Subject: RE: Planning Consultation on: AB/136/21/PL

Engineers Comments Regarding Surface Water Drainage

Application No: AB/136/21/PL

Site Address: Land Adjacent to 18 Queens Lane Arundel BN18 9JN

Figure 8.2 – Indicative drainage layout plan showing the proposed location of SuDS.

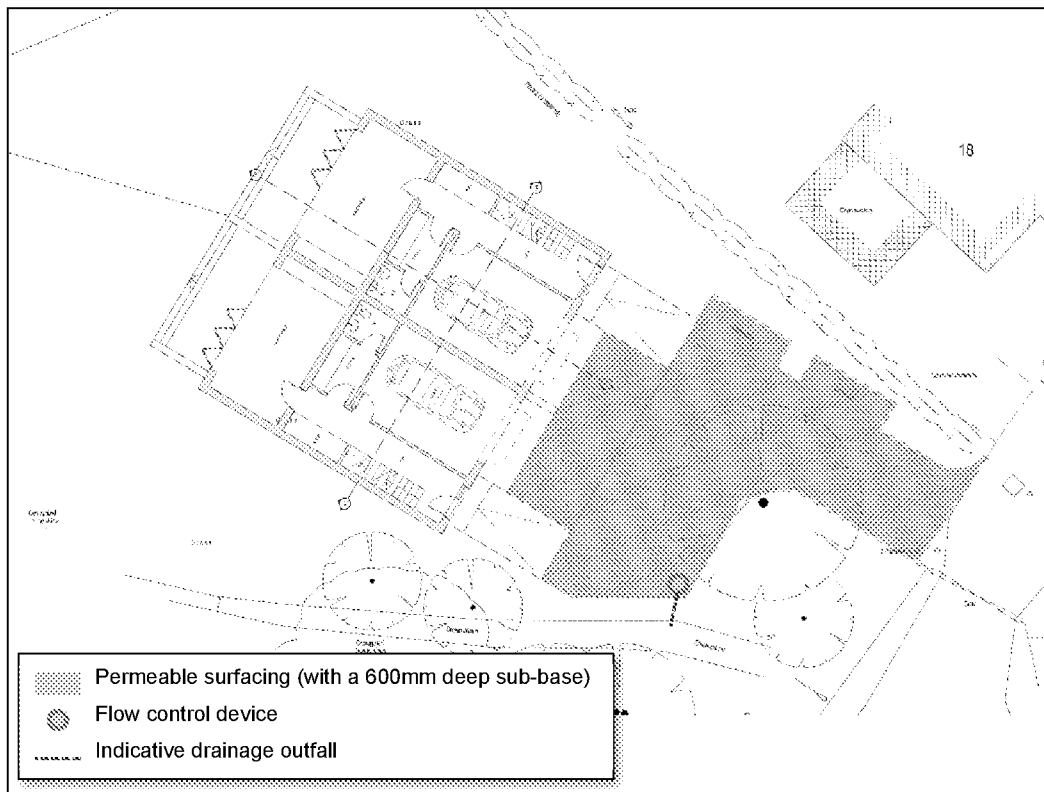
The applicant has provided a high level surface water drainage strategy, in which they proposed to attenuate surface water in permeable paving with a 600mm sub-base. The strategy has not been analysed in detail as it is not supported with site specific groundwater monitoring or infiltration testing. However, I note that there is a large tree shown on the drainage layout in close proximity to the proposed permeable paving. The same tree does not appear to be shown on the existing site plan or the proposed site plan, however, if it's presence is confirmed it will likely conflict with the surface water drainage strategy. This will need to be investigated further with the assistance of the Tree Officer if you are minded to approve the application.

I would have preferred all surface water drainage to be agreed prior to determination, however, given that the applicant has overcome the EA objection, has supplied a high level strategy showing that there is likely enough space on the site for surface water drainage, and that there is not enough time before the determination deadline to agree a detailed design I will accept this being approved via the following condition if you are minded to approve the application.

"Development shall not commence, other than works of site survey and investigation, until full details of the proposed surface water drainage scheme have been submitted to and approved in writing by the Local Planning Authority. The design should follow the hierarchy of preference for different types of surface water drainage disposal systems as set out in Approved Document H of the Building Regulations, and the recommendations of the SuDS Manual produced by CIRIA. Winter groundwater monitoring to establish highest annual ground water levels and winter percolation testing to BRE 365, or similar approved, will be required to support the design of any infiltration drainage. No building / No part of the extended building shall be occupied until the complete surface water drainage system serving the property has been implemented in accordance with the agreed details and the details so agreed shall be maintained in good working order in perpetuity."
